September 9, 2021

**Re: Summary of Modifications to Meet EPC Conditions of Approval  
Albuquerque Studios Expansion  
Amendment to the Mesa del Sol Level B Plan**

This letter outlines the modifications that have been made to the Mesa del Sol Level B Amendment application to amend their site development plan (PR-2021-005684) to meet the conditions of approval outlined in the Notice of Decision issued on August 19, 2021.

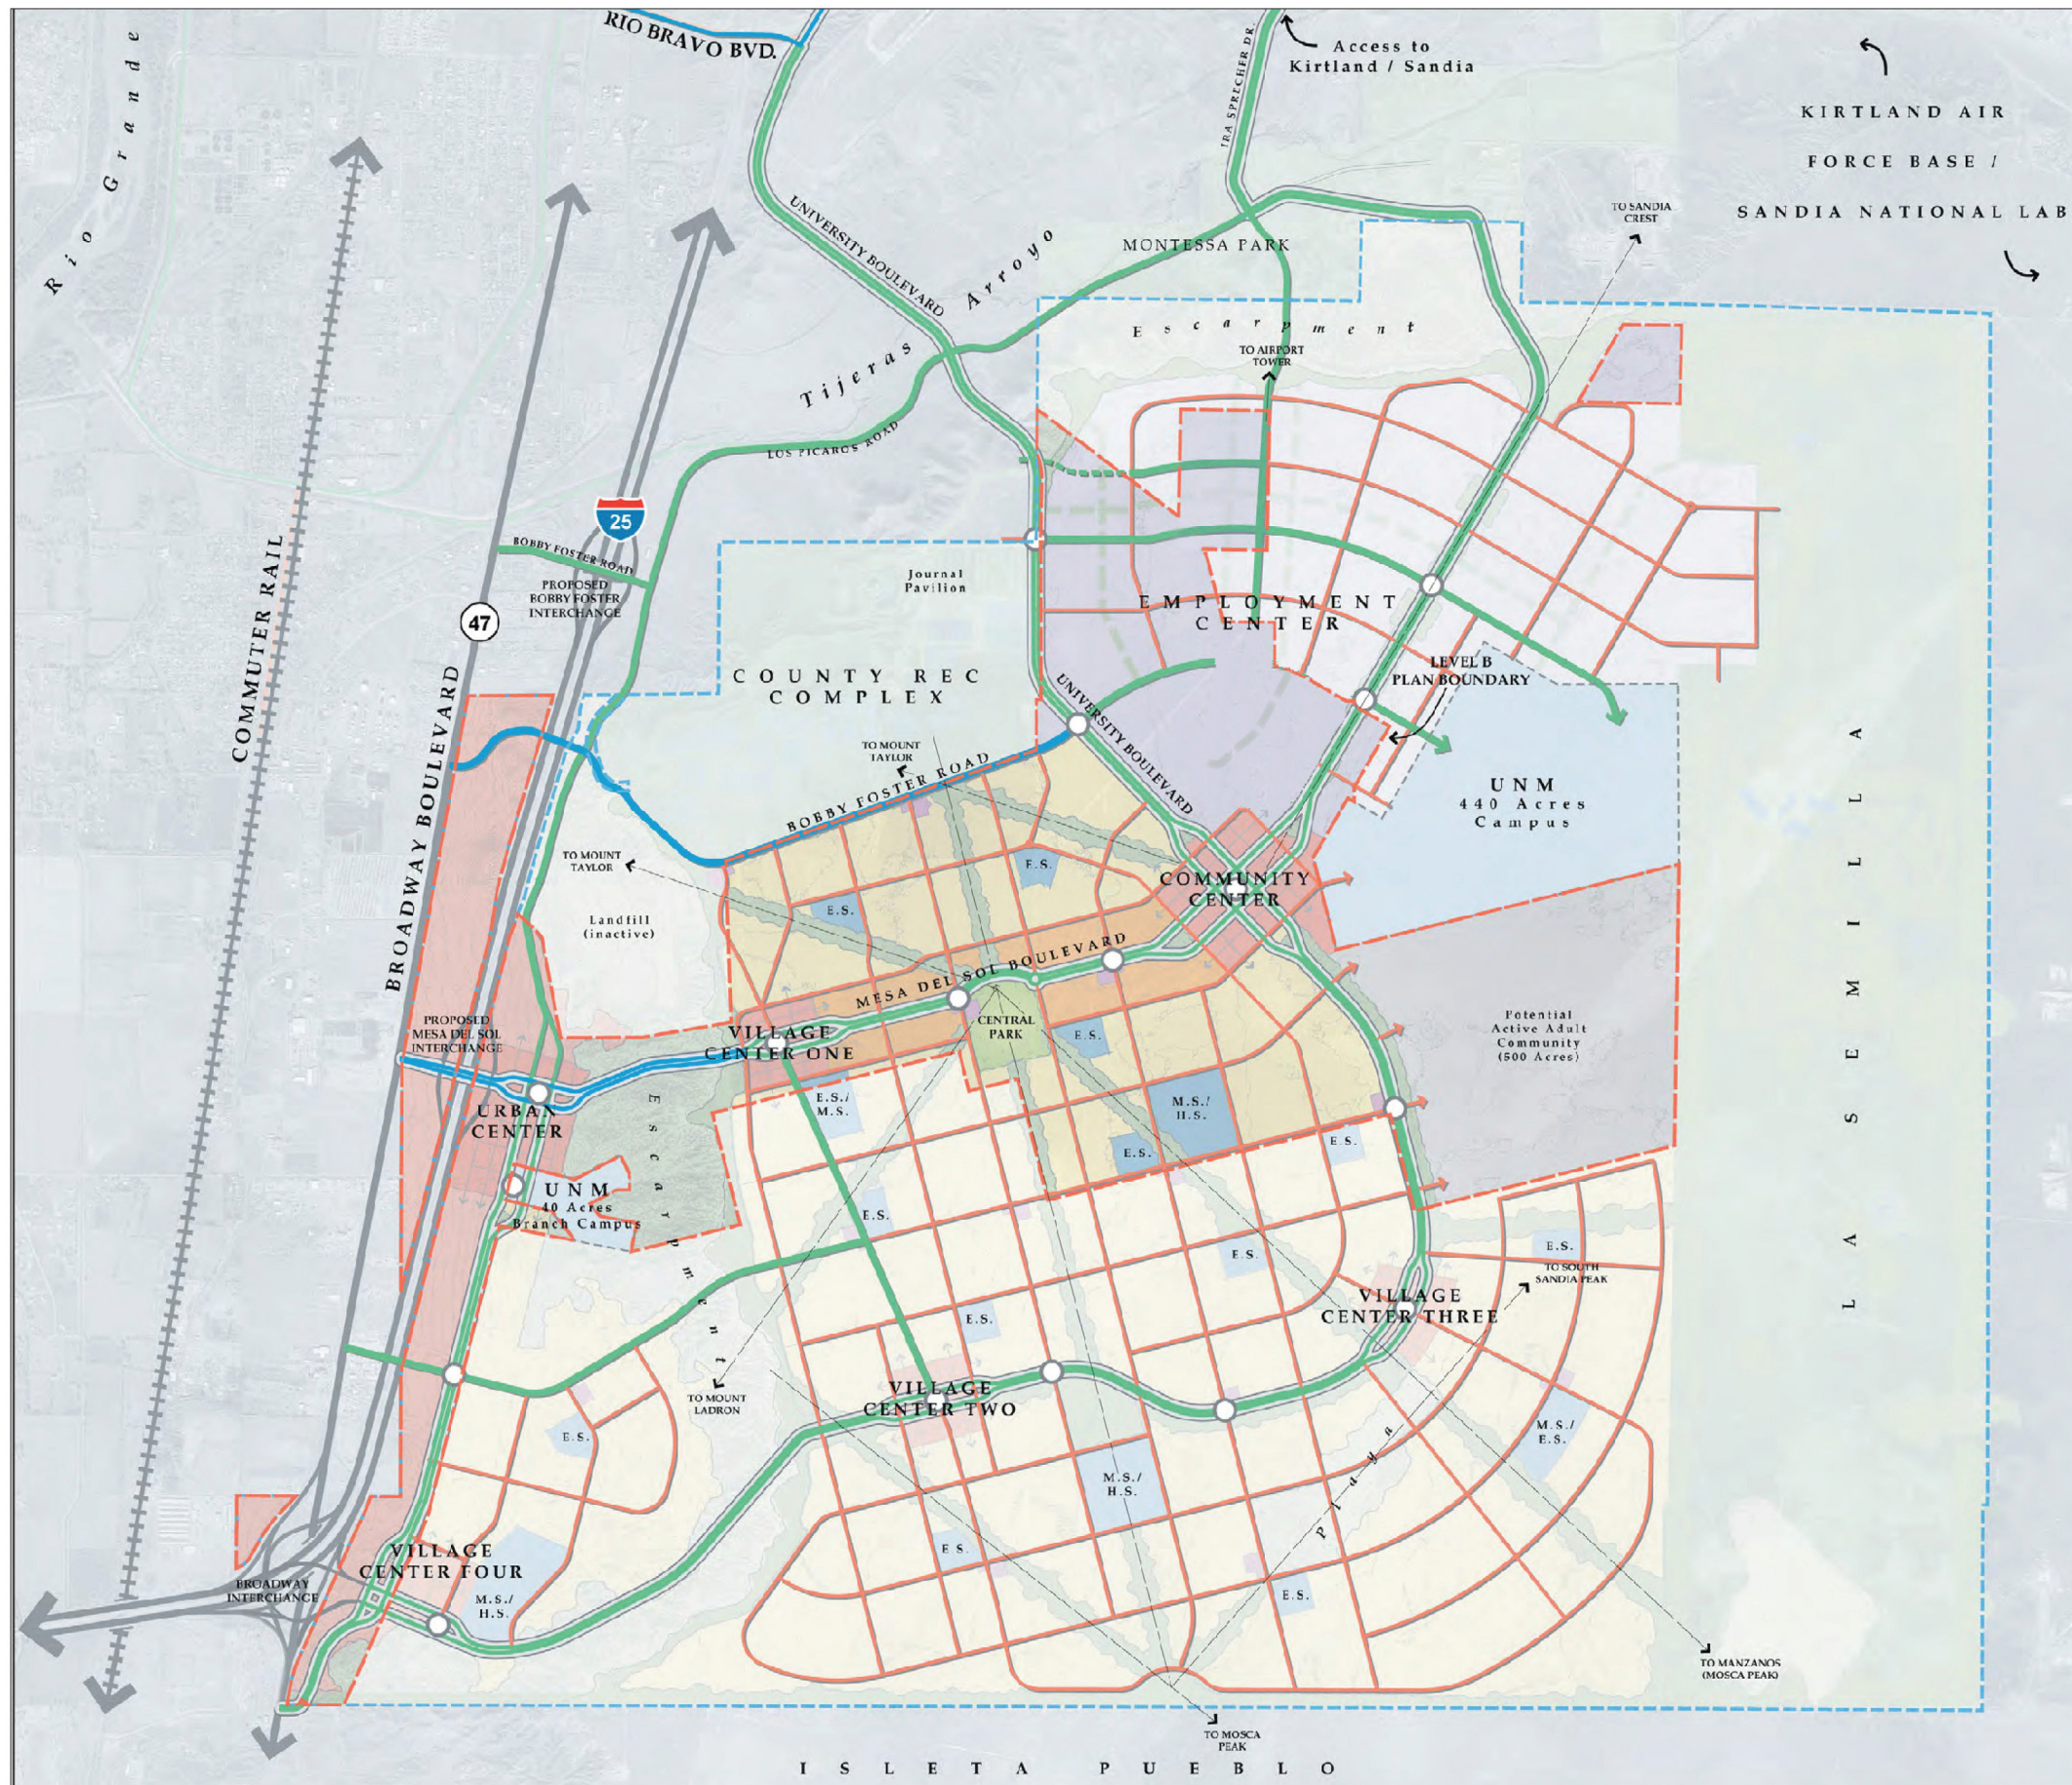
- A. Figure 2-3: Reference shall be changed to p. 42 and the proposed change map “pending” shall be provided.**
- B. Figure 3-1: The grid of local roads (orange) shall continue to be shown in the background.**

The applicant has updated Figure 2-3 to reflect updates to the proposed phasing. In addition, Figure 3-1 has also been revised to include the grid of local roads that exist outside of the subject site.

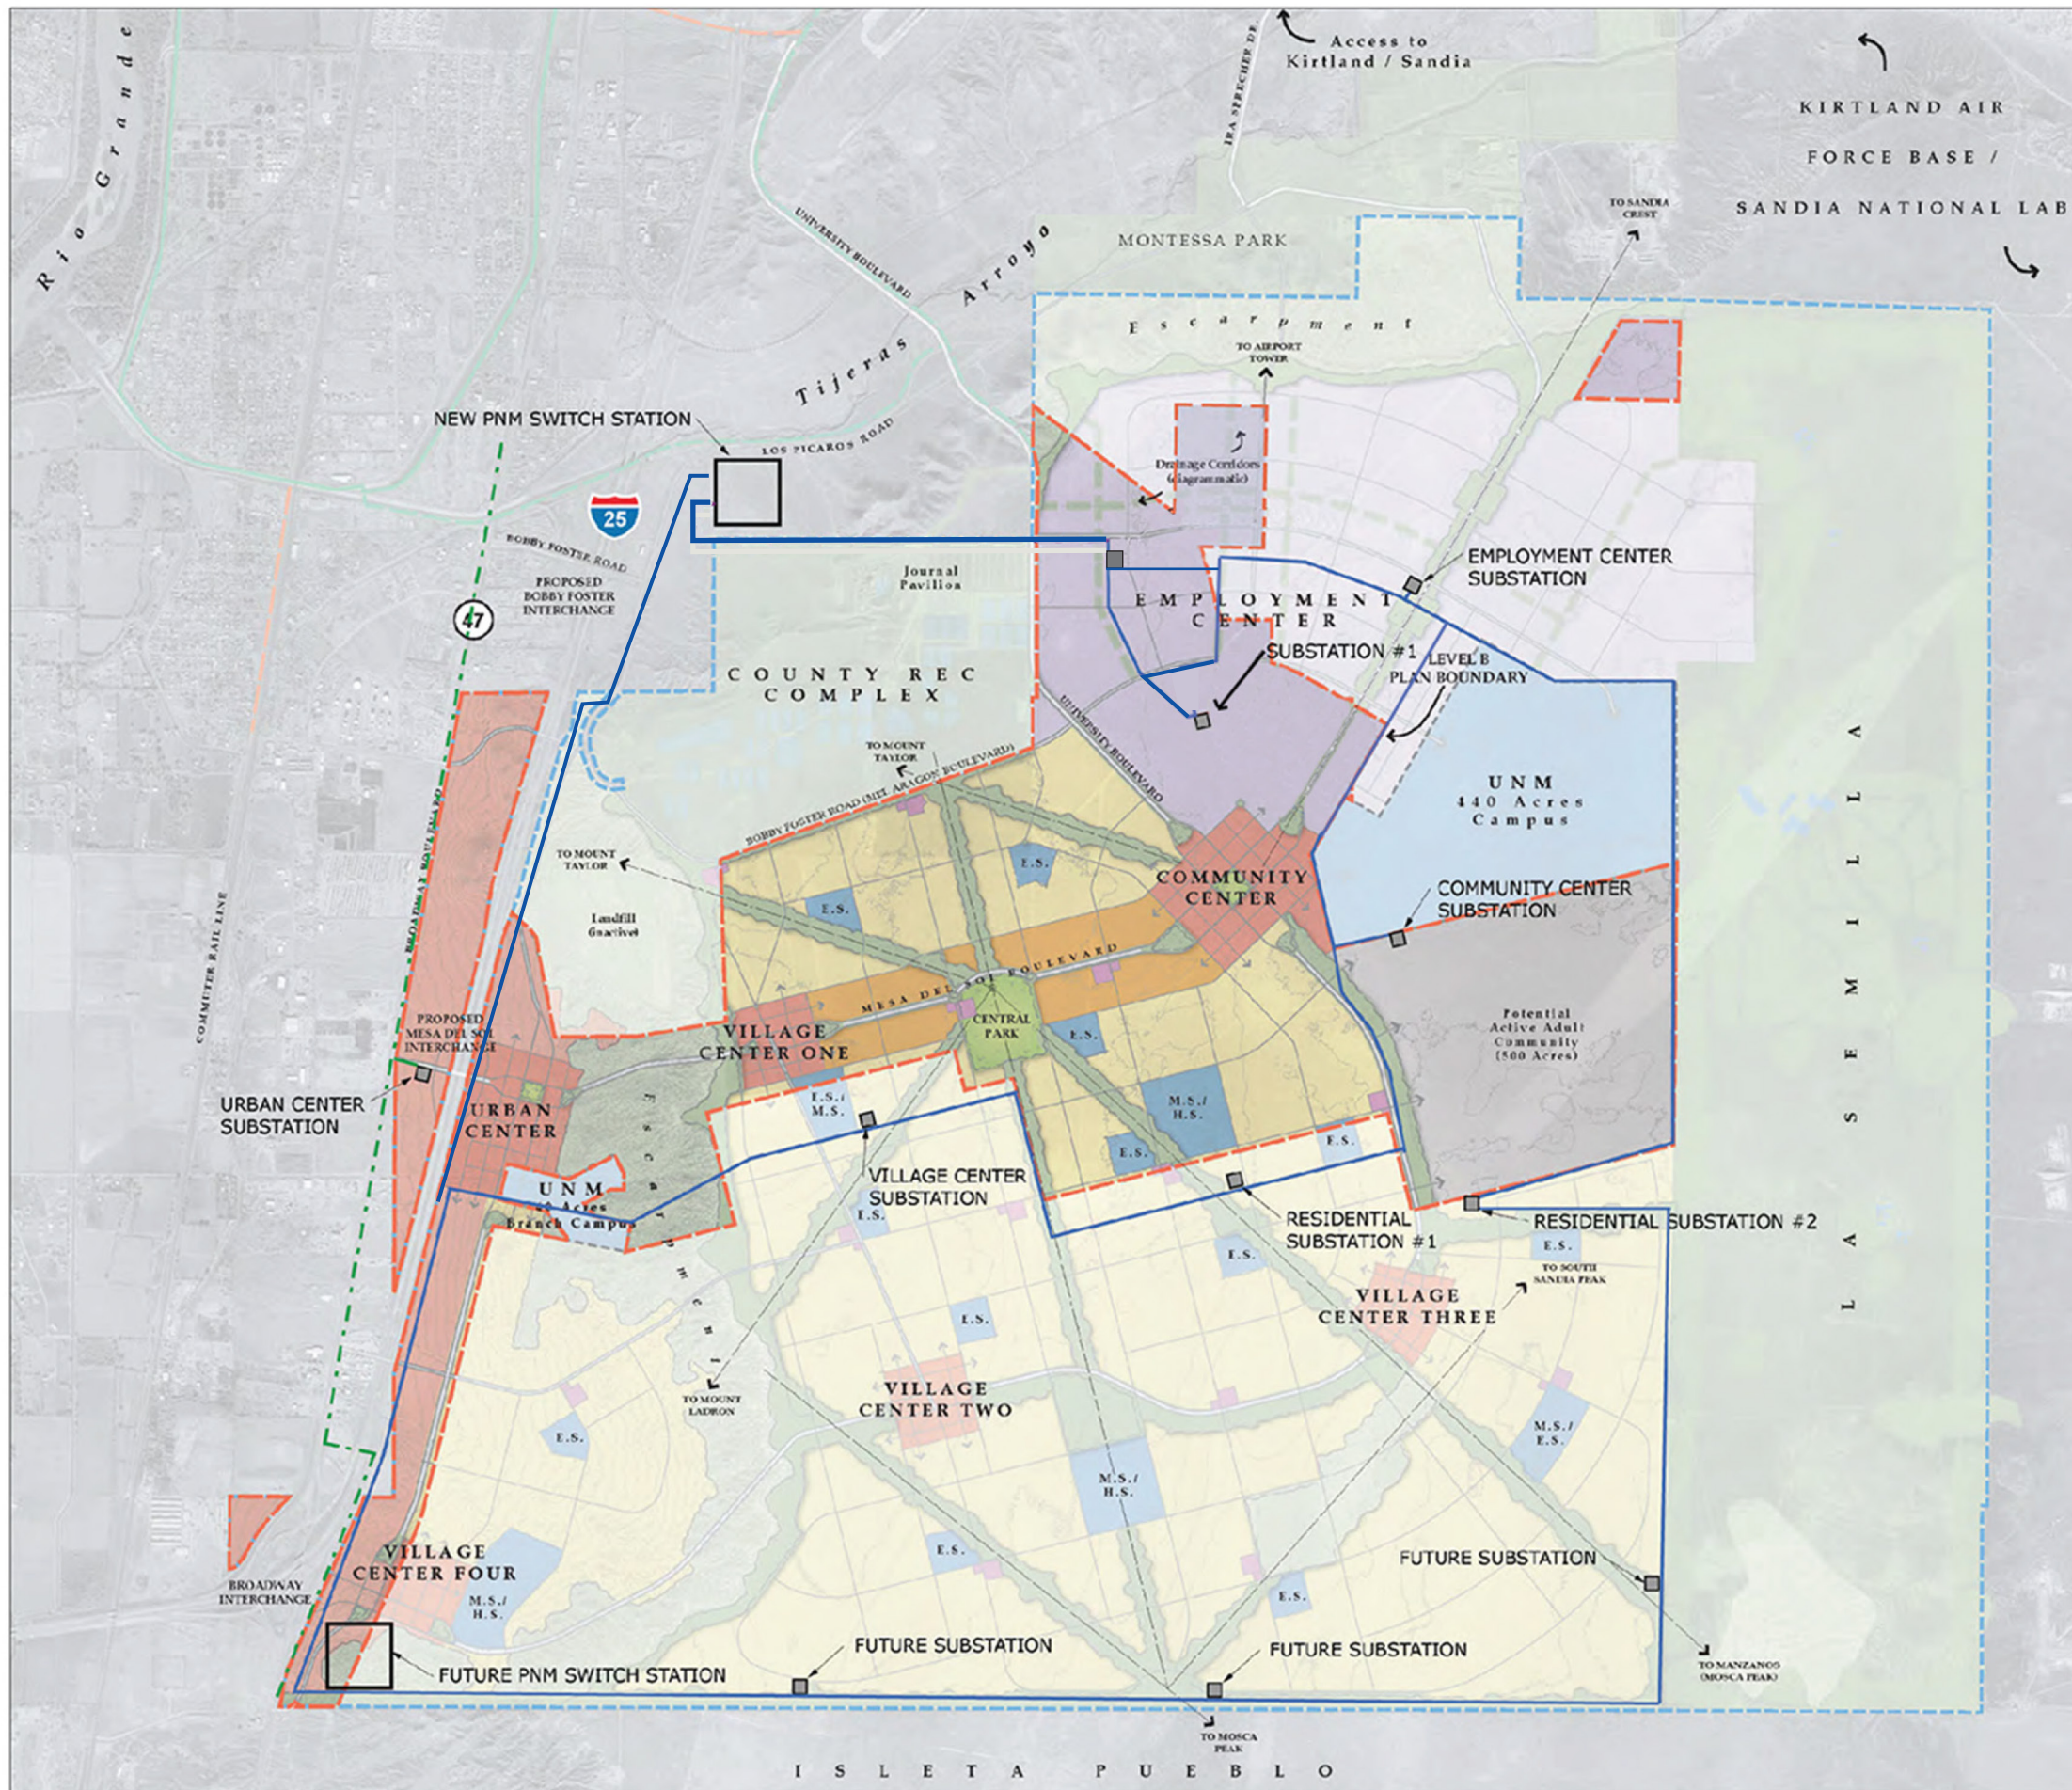
**D. Figure 5-5 and Figure 5C-1:**

- i. Legend: Consolidate the two symbols (purple dashed line and blue line) and their descriptions "Double Circuit Overhead Transmission Line" and "Single Circuit Overhead Transmission Line" into one symbol (blue line) described as "Overhead Transmission Line" and adjust line on map.***
- ii. Retain "SUBSTATION #2"***
- iii. Legend: Change description for green line to "Existing Transmission Lines."***
- iv. Retain transmission line corridor from SUBSTATION #2 to EMPLOYMENT CENTER SUBSTATION.***
- v. Show transmission lines coming into and out of SUBSTATION #1 as parallel and closer together.***
- vi. Show a new transmission corridor that connects/loops from the URBAN CENTER along the west/northwest Mesa del Sol boundary to NEW PNM SWITCH STATION.***

The applicant has revised the appropriate sections to address all the requested PNM revisions shown above. The applicant will continue to coordinate with PNM during platting and development to identify, locate, and secure necessary easements.
